Recommendation Report for Planning Permission

REF NO: FP/124/21/PL

LOCATION: Rear of 7 Middleton Road
Felpham
PO22 6BL

PROPOSAL: Detached double garage. This site is in CIL Zone 4 (Zero Rated) as other development.

PL01 - Proposed Garage

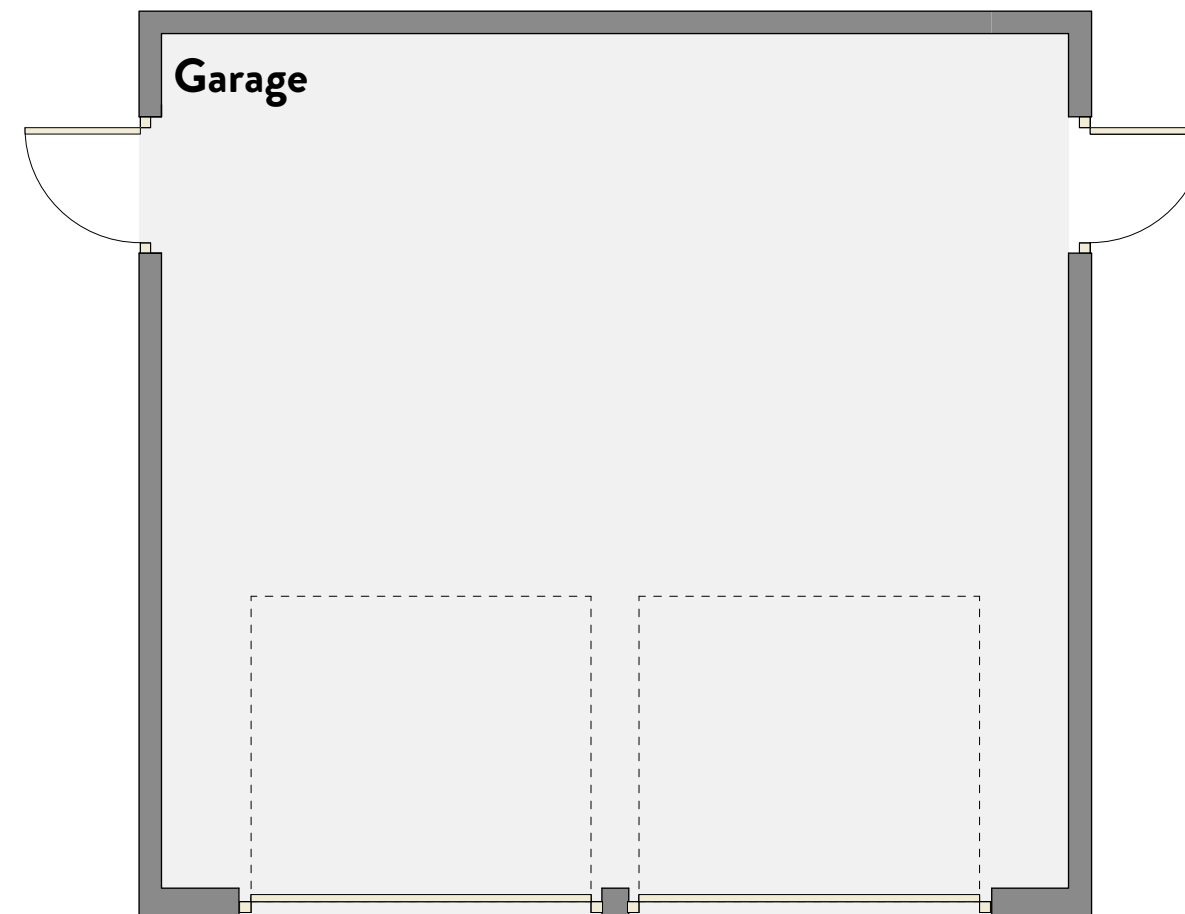
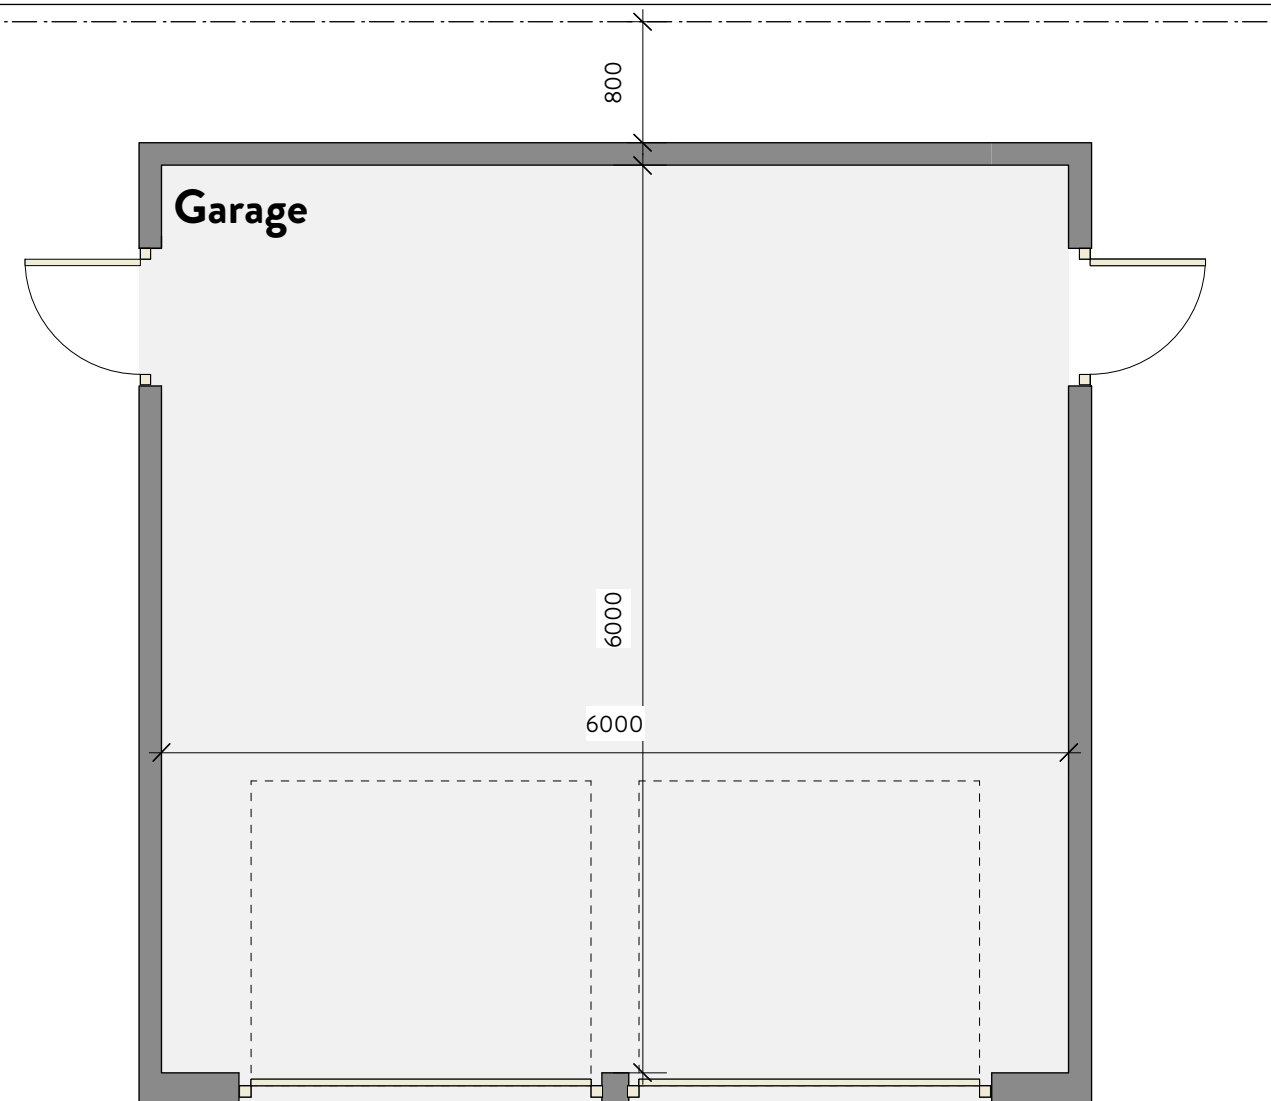
WSCC - Do not consider that this proposal would have an unacceptable impact on highway safety or result in 'severe' cumulative impacts on the operation of the highway network, therefore is not contrary to the NPPF (para 109), and that there are no transport grounds to resist the proposal. However, the proposed garage will have approximate internal dimensions of 6m x 5.6m. This falls slightly short of the minimum internal specifications for double-car garages of 6m x 6m as set out in Manual for Streets (MfS). Therefore, the LHA cannot consider the garage for parking provision and advises the applicant to enlarge the garage to 6m x 6m.

Comments noted. Addressing the above comments the applicant provided amended plans showing the internal dimensions of the proposed garage of 6m x 6m.

The proposed garage as amended would have approximate internal dimensions of 6m x 6m. This would satisfy the requirement of Arun Design Guide.

WSCC acknowledges the garage provides additional parking for the proposed dwelling and there is space for on-site turning to be achievable, allowing cars to exit the site in a forward gear. Amended drawings show the proposed garage which would meet MfS specifications for double-car garages of 6m x 6m.

PL02 - Proposed Garage

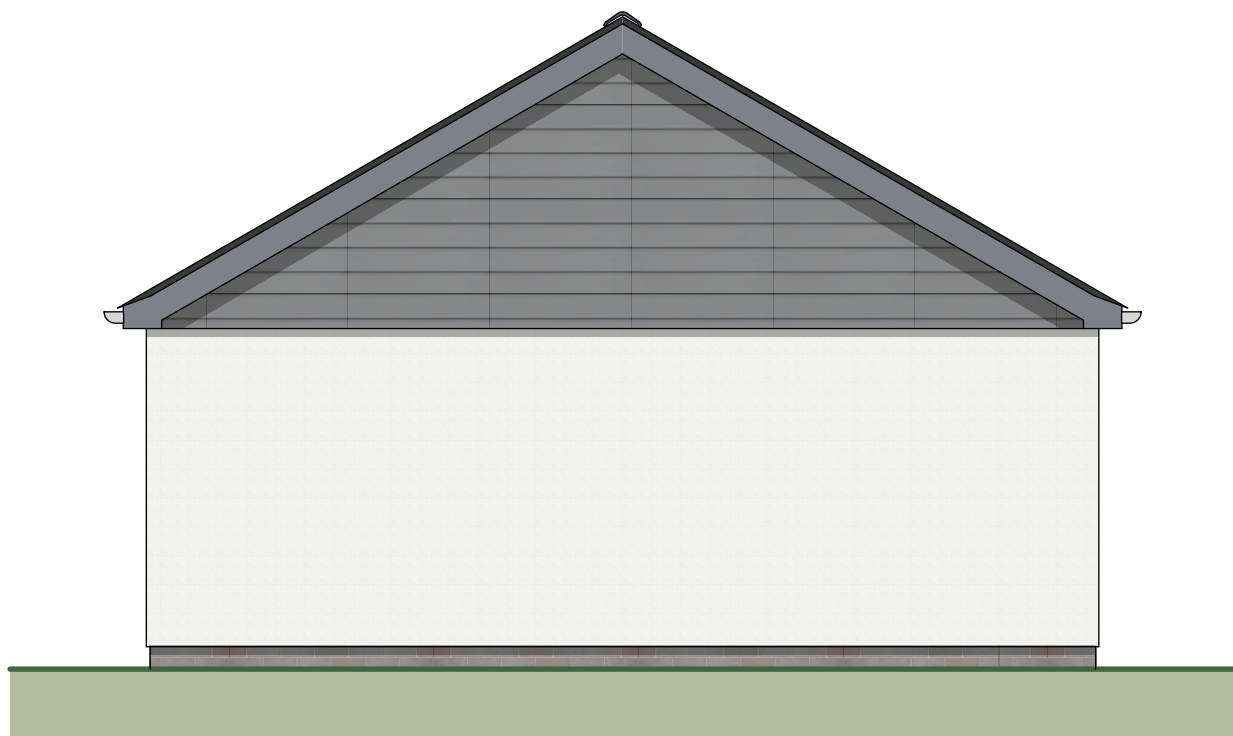
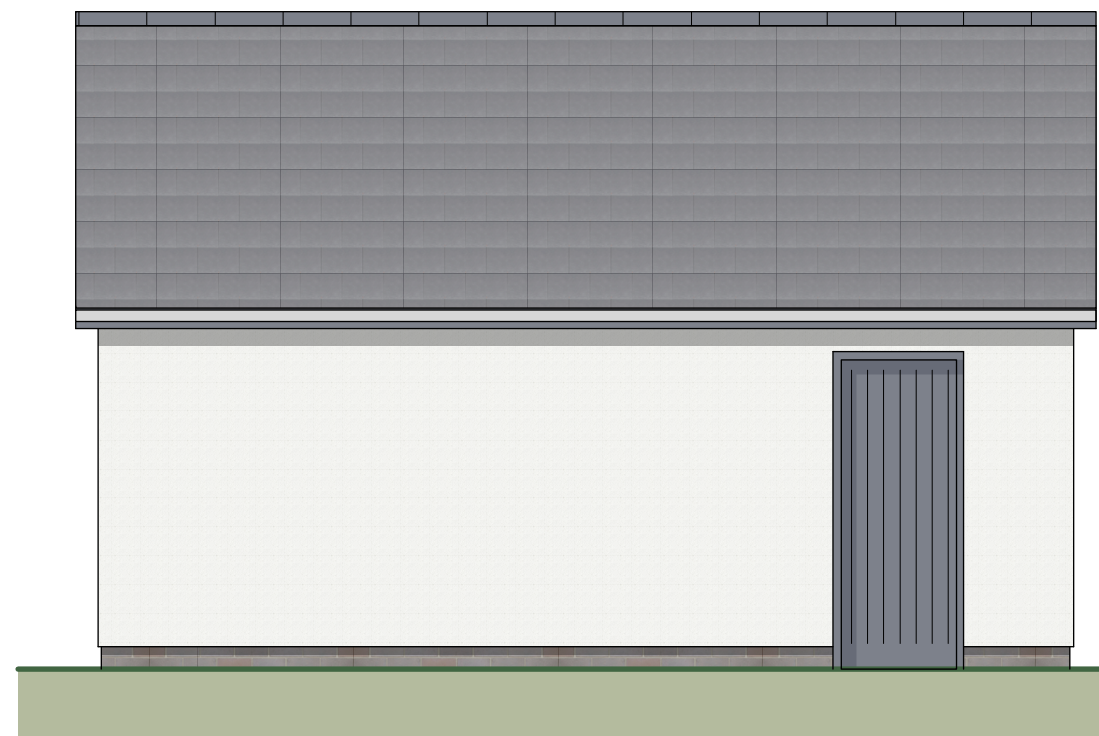
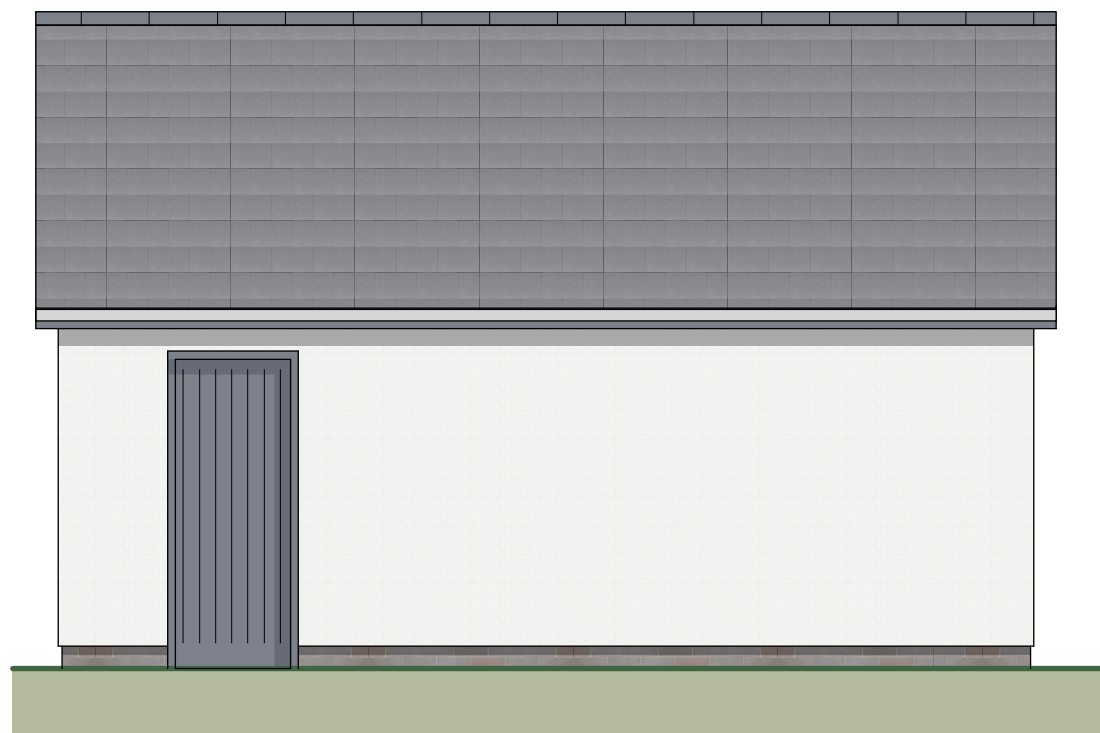
This application put forward a design with a shallow pitched roof with two gables which is traditional and sympathetic to the appearance and materials of the existing dwelling at Number 7, as well as the proposed dwelling to the rear. There would be a side doors; one on northern and one on southern elevation. Eave level would be 2.25m and the ridge 4.34m.
